Rezoning Transportation Analysis

Petition Number: 2021-159

Date	Description
11-21-21	First Review (TNM)

Drawing No. **RZ-1.0**

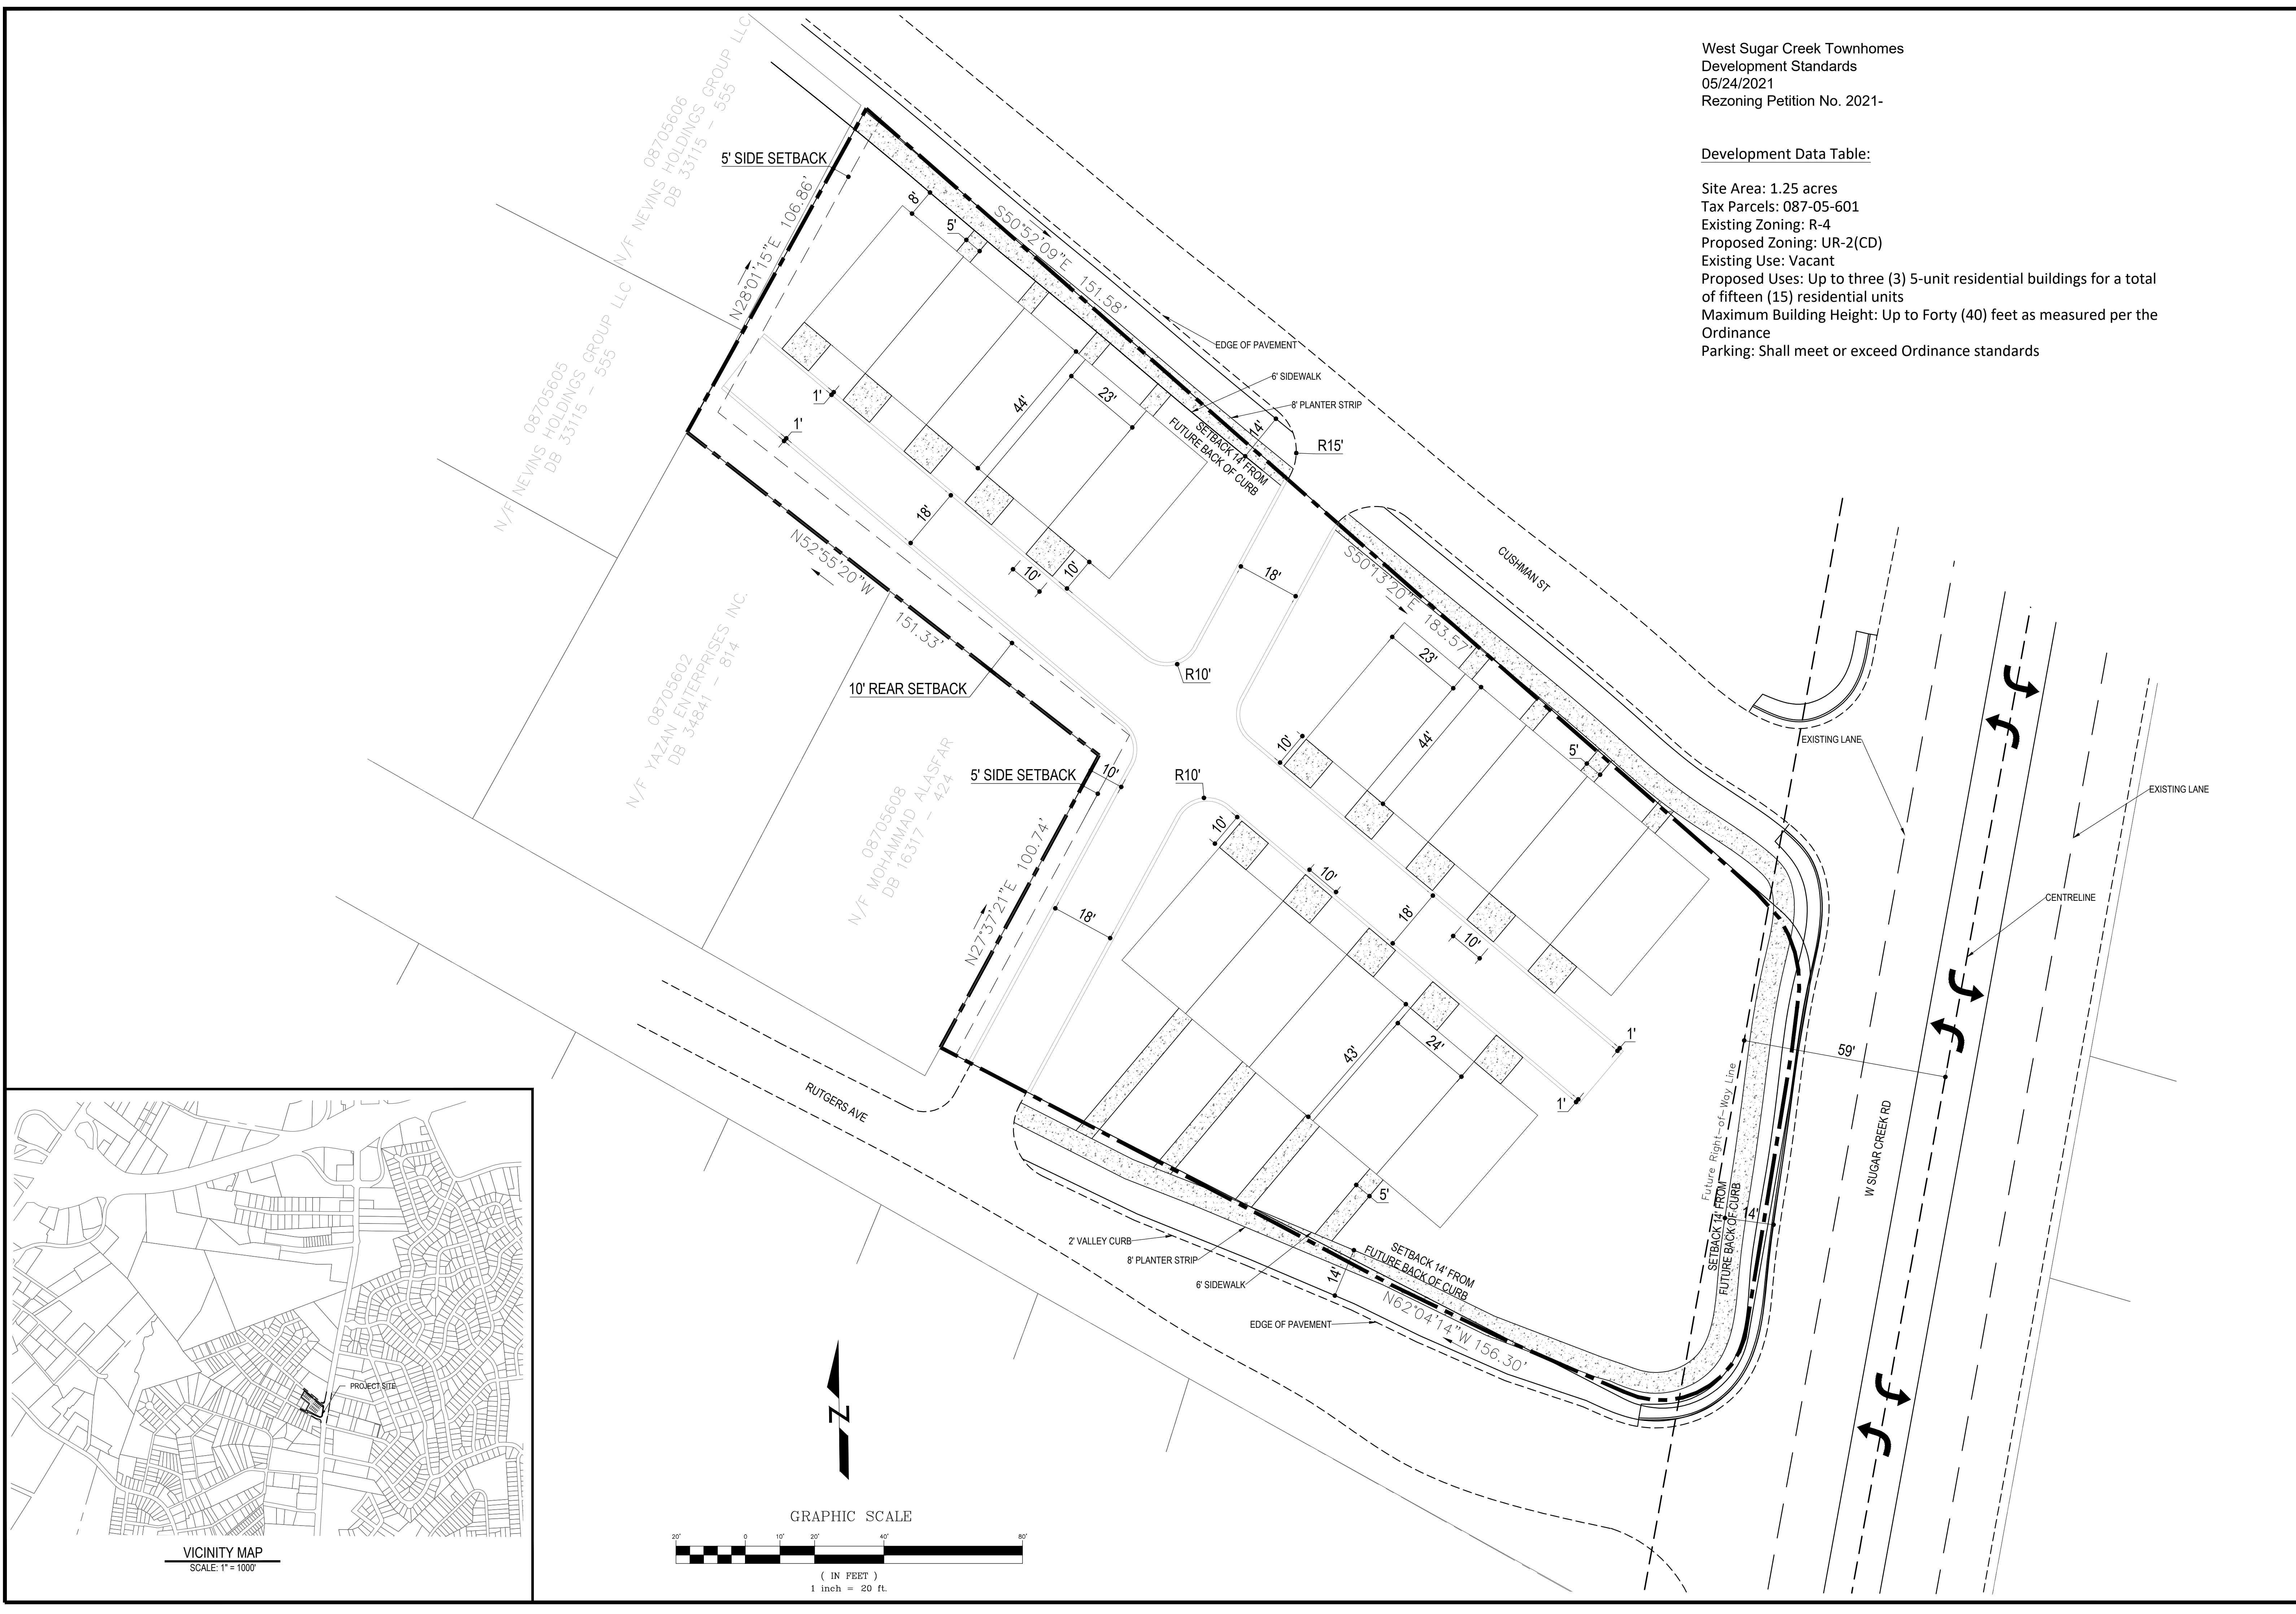
Site plan revisions are needed to meet ordinance requirements and the outstanding items include, but are not limited to dimensioning the Right Of Way from the centerline of Cushman Street, Rutgers Avenue, and Sugar Creek Road, clarifying the ownership and standard of the site's internal roadways, specifying all driveways to be type II modified driveways, providing visitor parking, showing the trash collection location, and adding ADA compliant ramps. Further details are listed below.

- Curblines:** The proposed zoning district has a setback measured from back of the existing or proposed future curblines.
 - West Sugar Creek Road:** the future location of curb and gutter is in its existing location.
 - Cushman Street:** This street currently does not have curb and gutter. Provide 2'-6" curb and gutter along the site's frontage.
 - Rutgers Avenue:** This street currently does not have curb and gutter. Provide 2'-6" curb and gutter along the site's frontage.

Label and dimension the curb and gutter from the centerline for each road on the site plan.

- Revise site plan and conditional note(s) to commit to dedicate 50 feet of right-of-way from the road centerline on West Sugar Creek Road. The site plan shall label and dimension the right-of-way from the road centerline.

- Revise site plan to show and dimension a 2-foot Sidewalk Utility Easement at the back of sidewalk if outside ROW along West Sugar Creek Road, Cushman Street and Rutgers Avenue.

- Revise site plan to show the driveways on Cushman Street and Rutgers Avenue as Type II Modified Driveways per CLDSM 10.25E.
- The proposed dwelling units exceeds 12 per acre. Per Chapter 20 Subdivision ordinance, site plan and conditional note(s) revisions are needed to commit to construct an 8-foot planting strip, and 12-foot multi-use path along West Sugar Creek Road. The wider path also meets the Charlotte WALKS Policy.

- Revise site plan to add visitor parking and the trash collection location for the site.
- Revise site plan to clarify the roads as Private and call out CLDSM detail of all internal roads on the site.

- Revise site plan to provide ADA compliant ramps at the corner of Sugar Creek and Rutgers and the corner of Sugar Creek and Cushman
